MODIFICATION REQUEST:

Blocks 6 and 7, Central Park

MP 11_0091 MOD 1

**Modification to internal and external components
of the approved commercial and retail
development**

Figure 2: Proposed amendment to Level 5 of No. 2-10 Kensington Street illustrating location of ventilation added to northern facade (Source: Architectural plans from Proponent's Application)

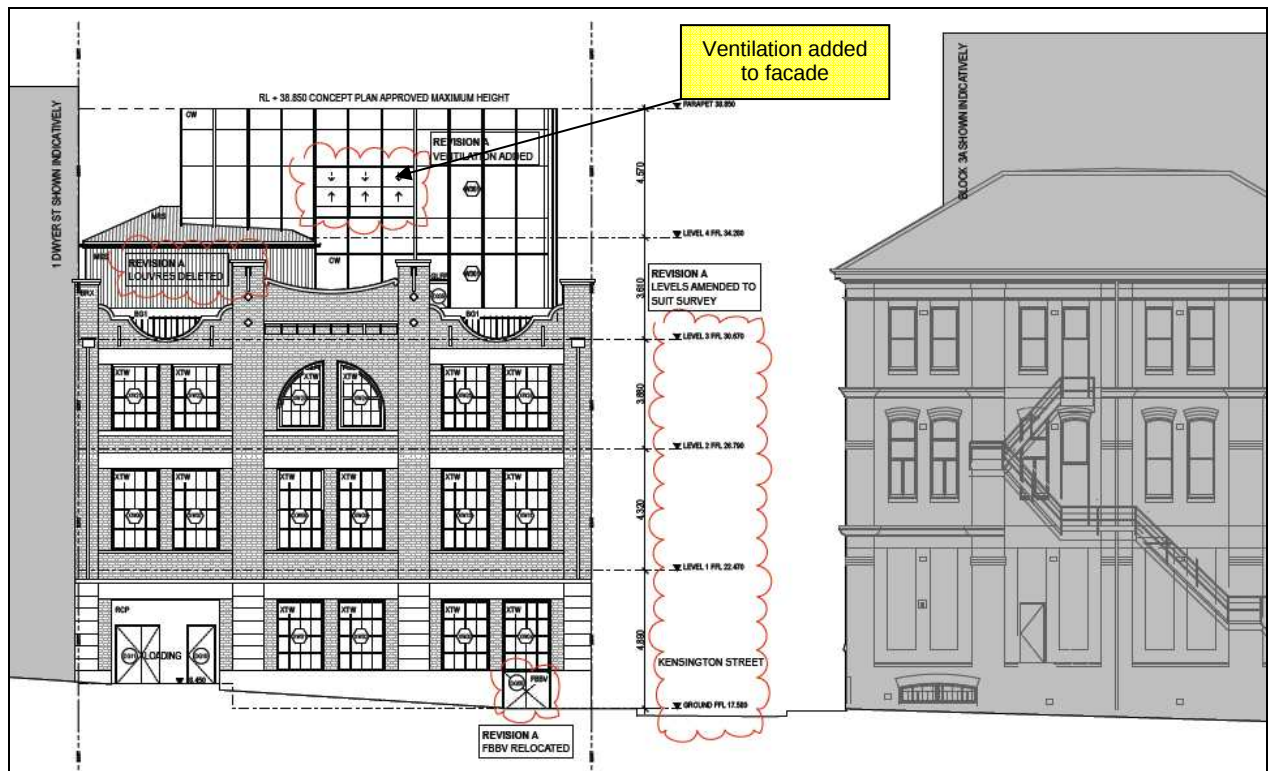
The proponent seeks to undertake minor internal modifications to the approved development, as illustrated in **Figure 2** and **3**. These predominantly include modifications to bathroom facilities and plant rooms, which are proposed to improve the efficiency and access throughout the buildings and into the rear laneways. The department supports these minor modifications that provide greater access to these areas.

Figure 3: Proposed amendments to ground floor of development (Source: Architectural plans from Proponent's Application)

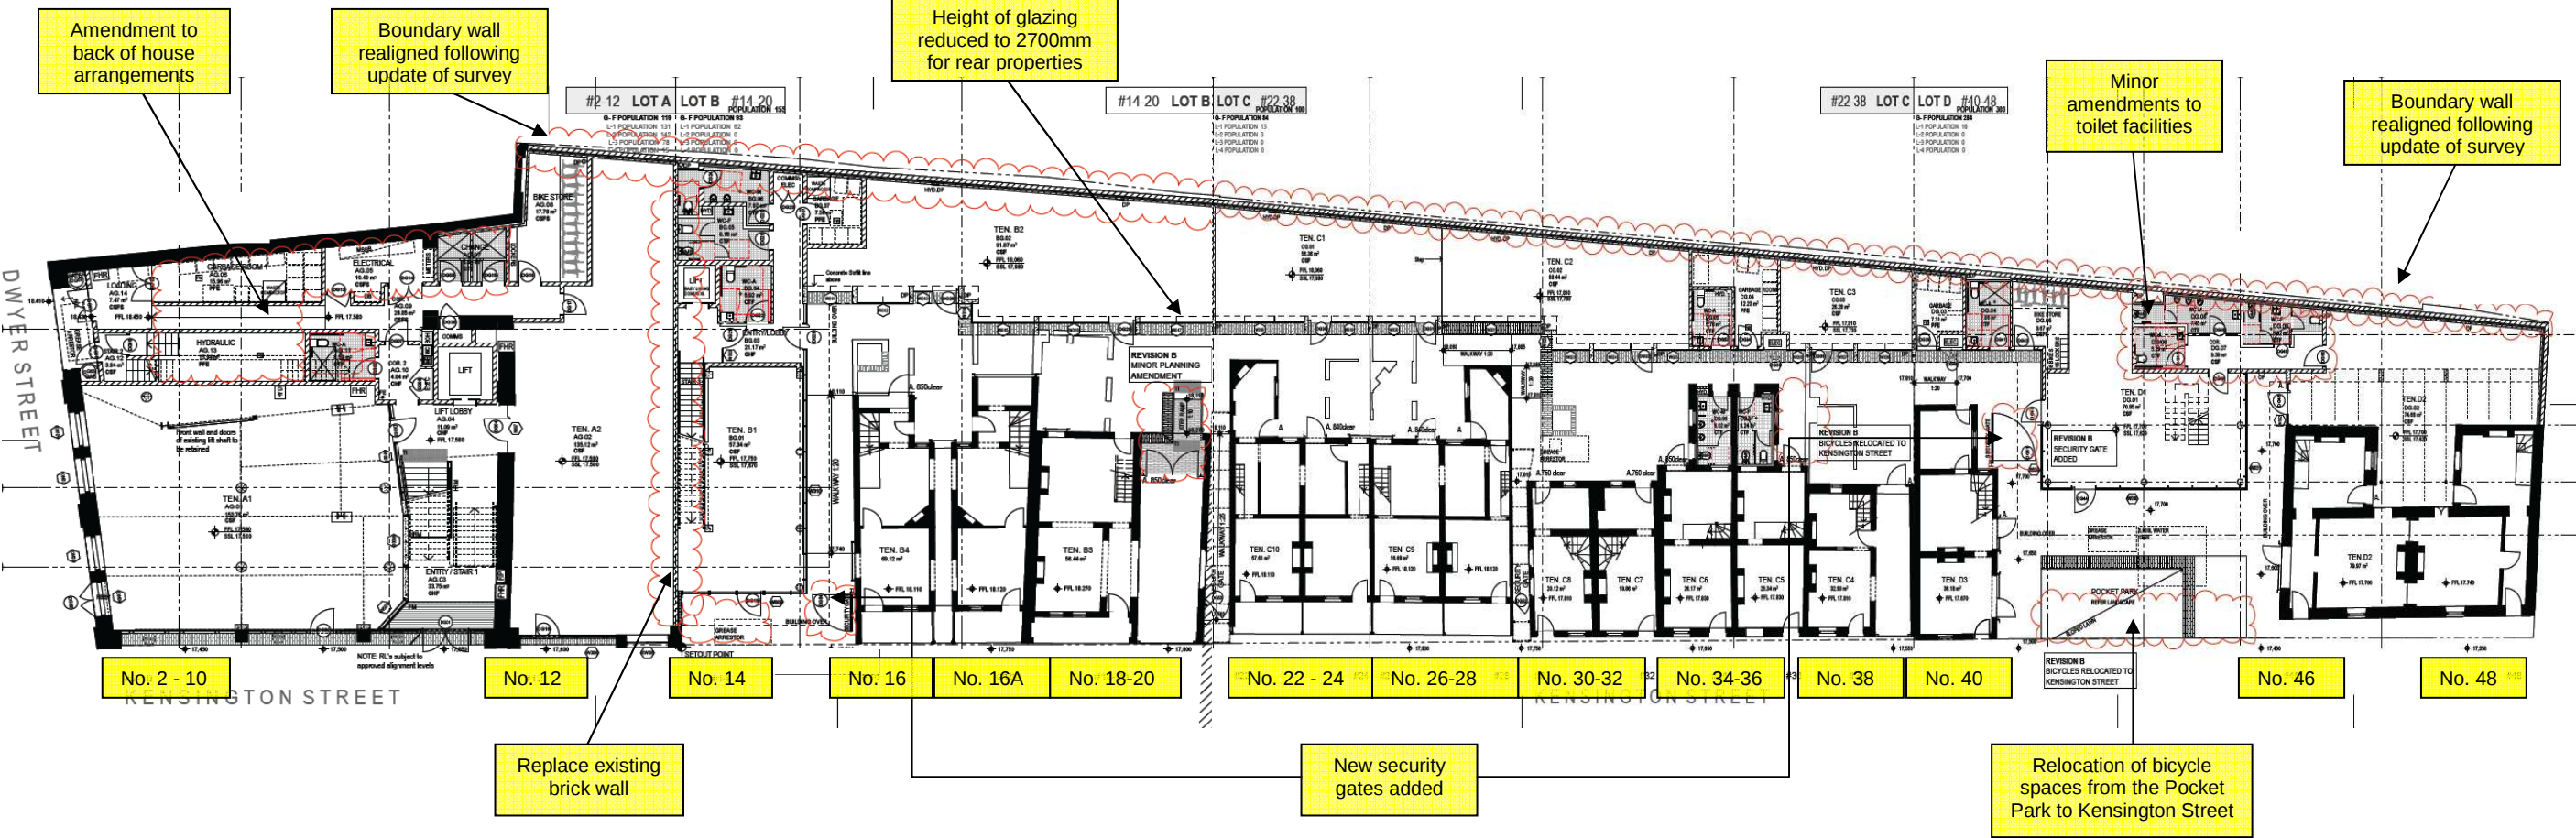
Another proposed amendment is the replacement of the existing dividing wall between No. 12 and 14 (ground and first floor), which was originally proposed to be retained. The existing wall has been found to be unstable and unsuitable for retention. The proponent's heritage consultant advised that the replacement of this internal wall will not have any negative impacts upon the heritage significance of the site. It is noted that Council also did not raise any concerns with this modification on heritage grounds. The department therefore supports this internal modification.

Figure 4: Proposed amendments to first floor of development (Source: Architectural plans from Proponent's Application)

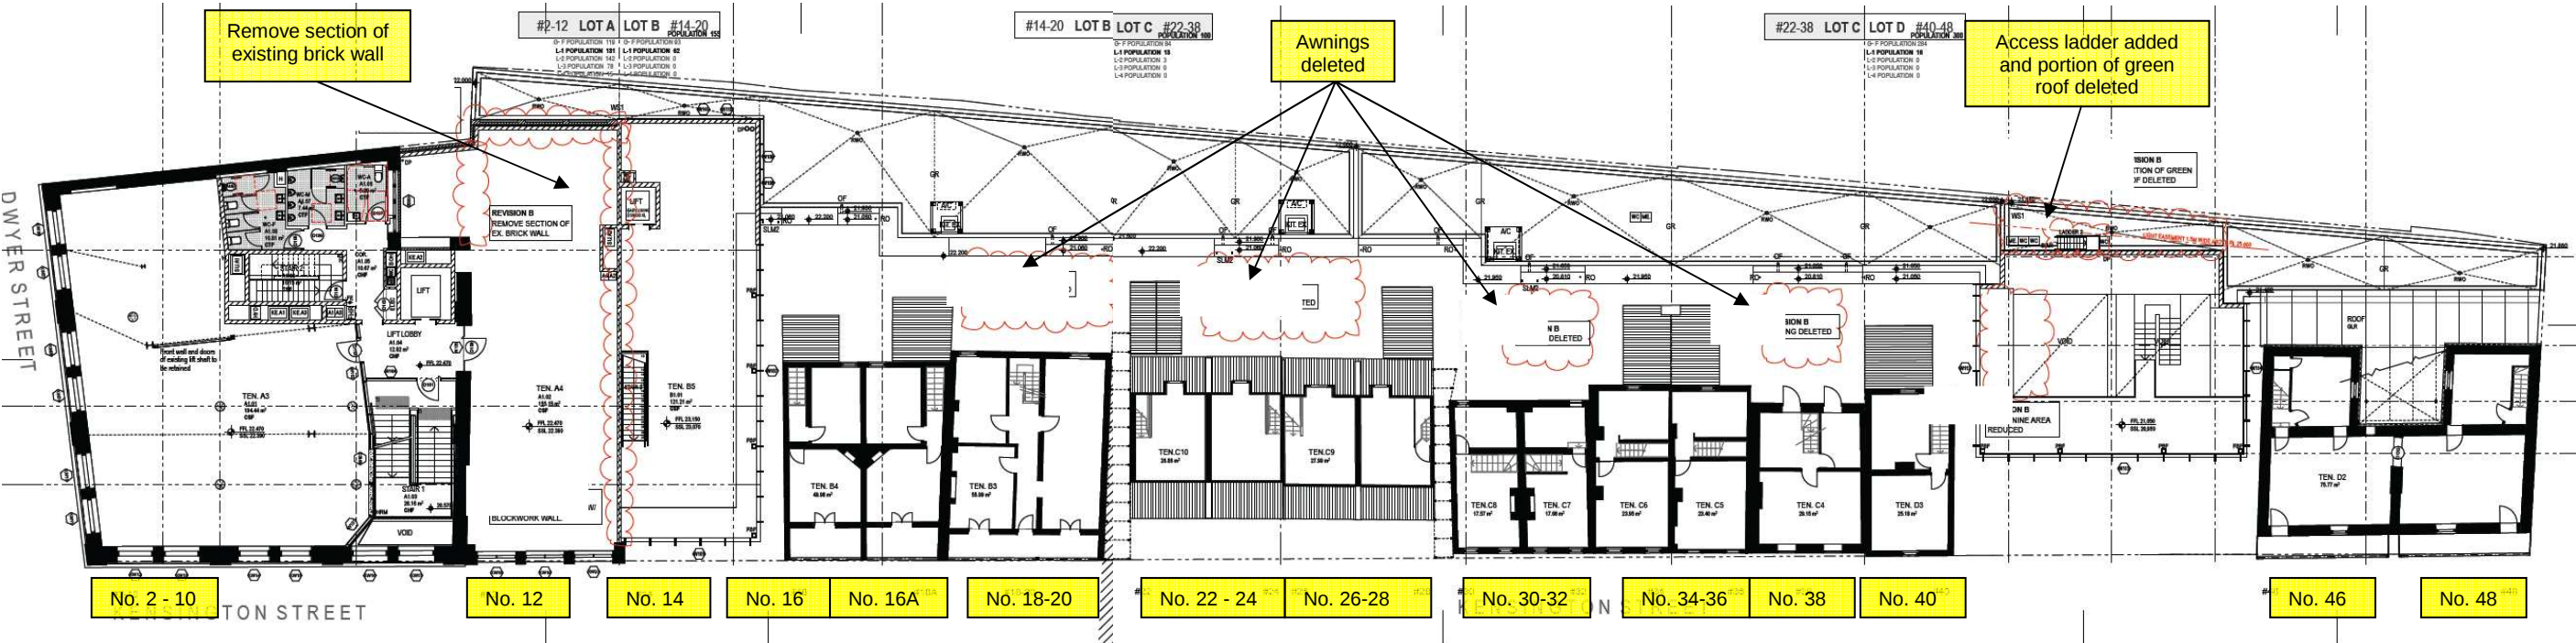
The modifications are detailed in **Figures 3 and 4** within Section 2 of this report.

The department considers that the majority of the modifications such as the removal of awnings and pergolas, inclusion of ladders, replacement of the exterior wall to No. 12 and street level amendments are minor in nature and do not impact upon adjoining properties or on the suitability of the proposal that was considered satisfactory during the assessment of the original application.

Figure 6: Approved (left) and proposed (right) modifications to parapet height at No. 40-42 Kensington Street (Source: Proponent's Application)

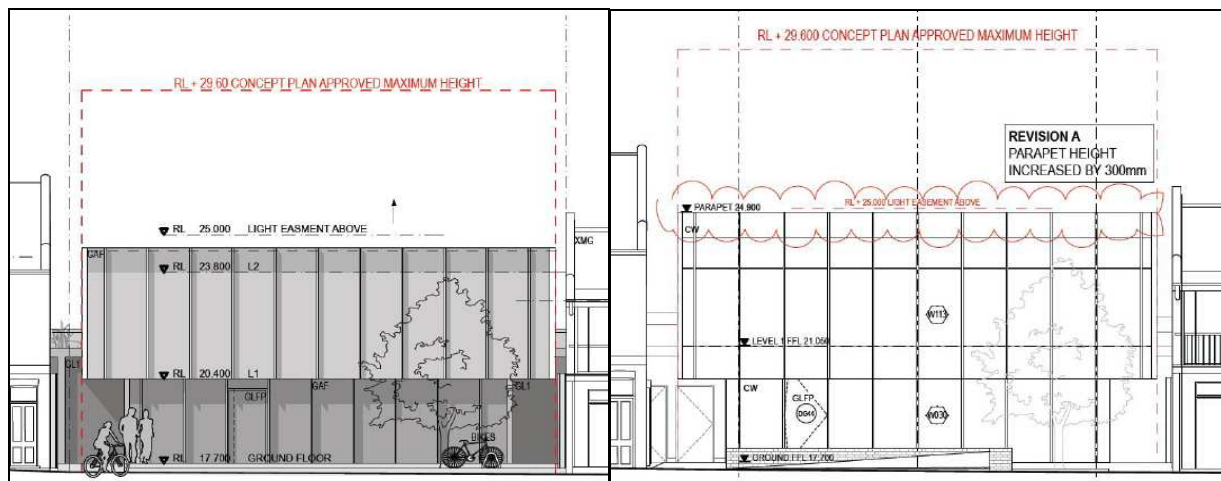
The proposed 300mm increase in height to the glass parapet height at No. 40-42 (raising to a maximum RL 24.90) will be visible from Kensington Street. A comparison between the approved and proposed elevation is provided at **Figure 6**. The increase in height of the parapet follows a refinement of the design to improve the appearance of the glass parapet to Kensington Street and ensure that it is of a similar height to the ridgeline of the buildings to the south.

The increase in height of the parapet does not impact upon the building light easement height of RL 25.00, which is provided to ensure light onto the Kensington Street public domain area. On this basis, the department supports this increase, noting that the minor increase will have minimal impacts on the external appearance and amenity of the Kensington Street public domain.

1 LONG SECTION & REAR WEST ELEVATION
1:100

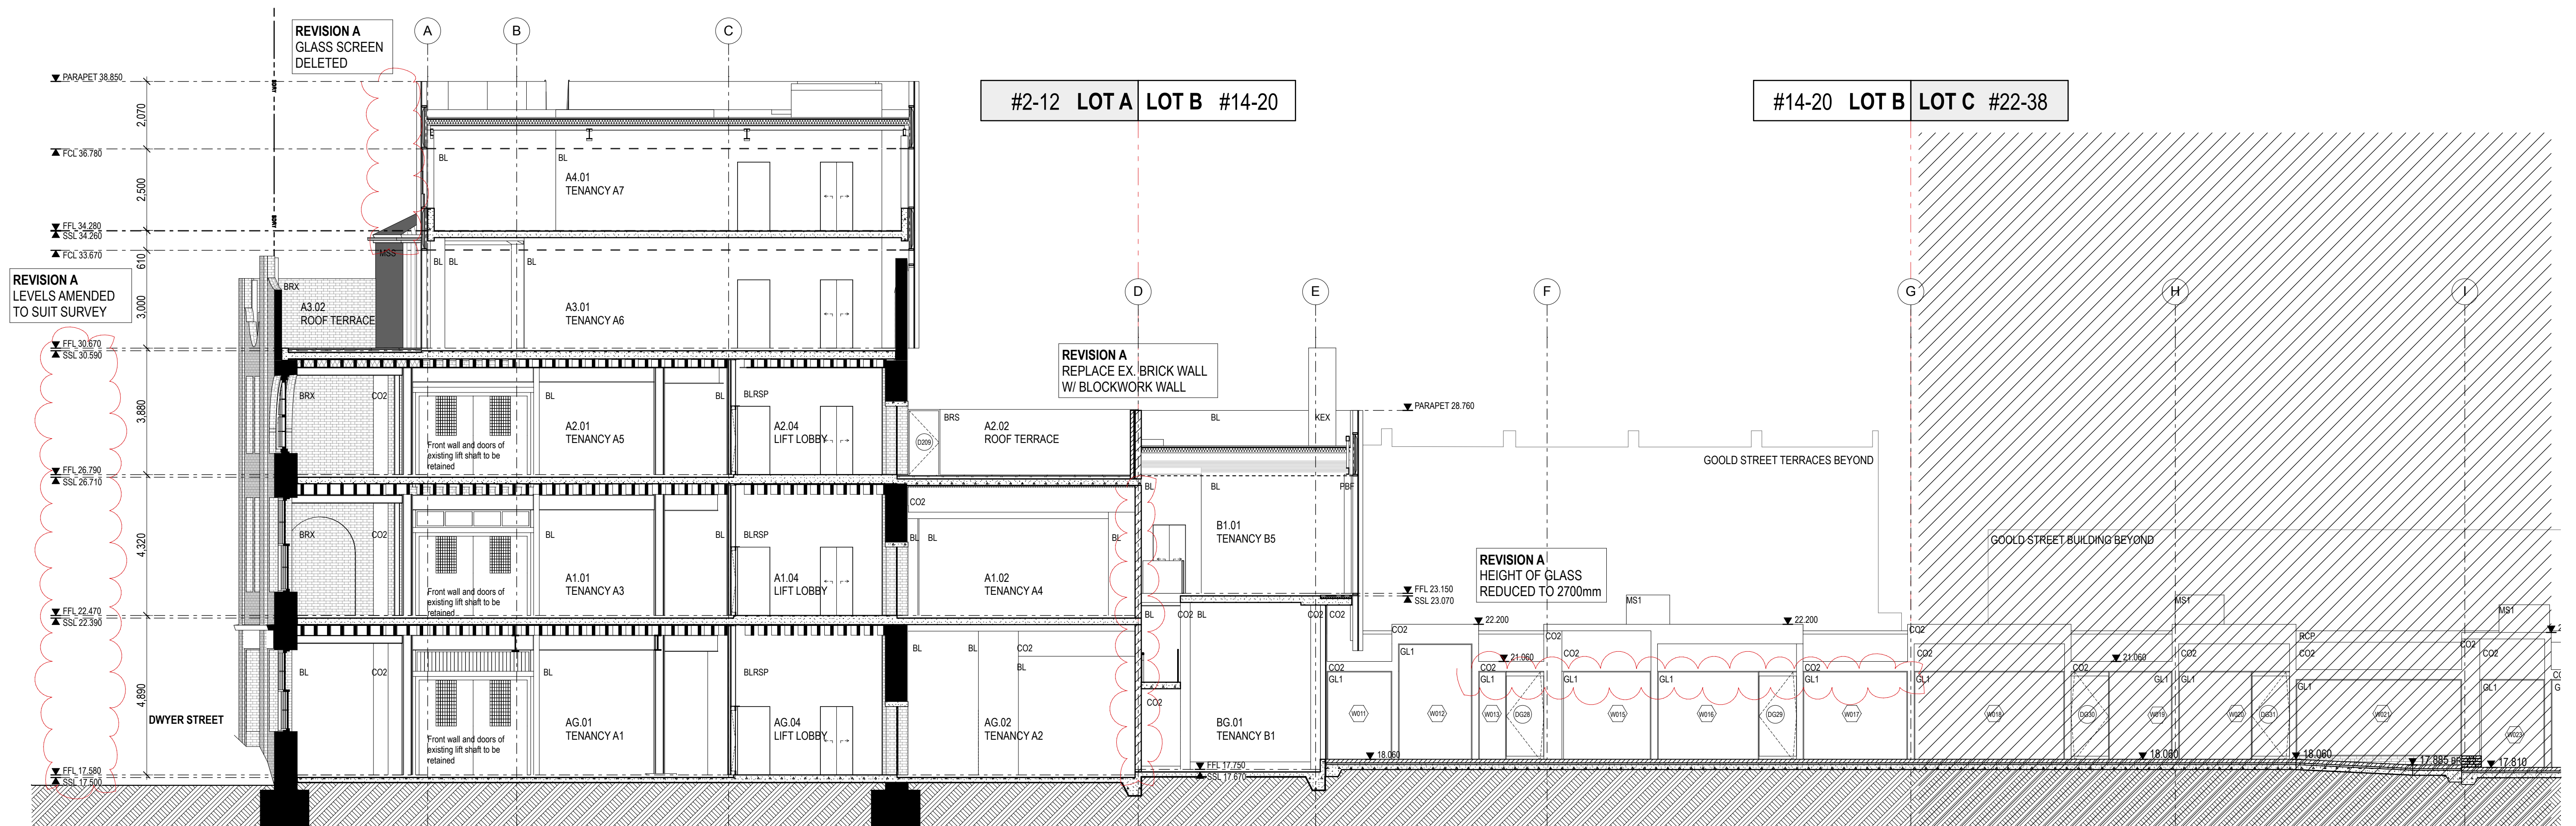
- the proposed internal and external modifications are generally supported;
- no concerns are raised with the deletion of condition B4 and B6(b); and
- concerns are raised with the proposal to reduce the height of the glazing on the western façade of the rear laneway buildings to 2.7 metres (this glazing was previously provided at varying heights across this facade) on the basis that the modification does not contribute to design quality of the buildings.

The approved glazing height on the western façade of the rear laneway building is to be reduced to 2.7 metres (this was previously provided at varying heights across this façade). A comparison between the approved and proposed elevation is provided at **Figure 7**. In support of the modification, the application was accompanied by a Heritage report which notes that there would be no heritage impact from this modification.

The proposed reduction in height of the glazing is considered to be an improvement over the extensive use of glazing compared that originally approved and is supported.

On 20 February 2014, the proponent responded to Council's concerns by providing additional justification for the proposed design, which included amended glazing diagrams and supporting comments as to how the modified designs achieve modulation along the parapets. In addition, comments were also provided on how the proposal has maintained acknowledgement of the heritage significance of the locality.

Council has since reviewed the additional information and has confirmed that the design quality of the proposed modification to the glazing height is acceptable and on this basis, it raises no objections to the amended application.
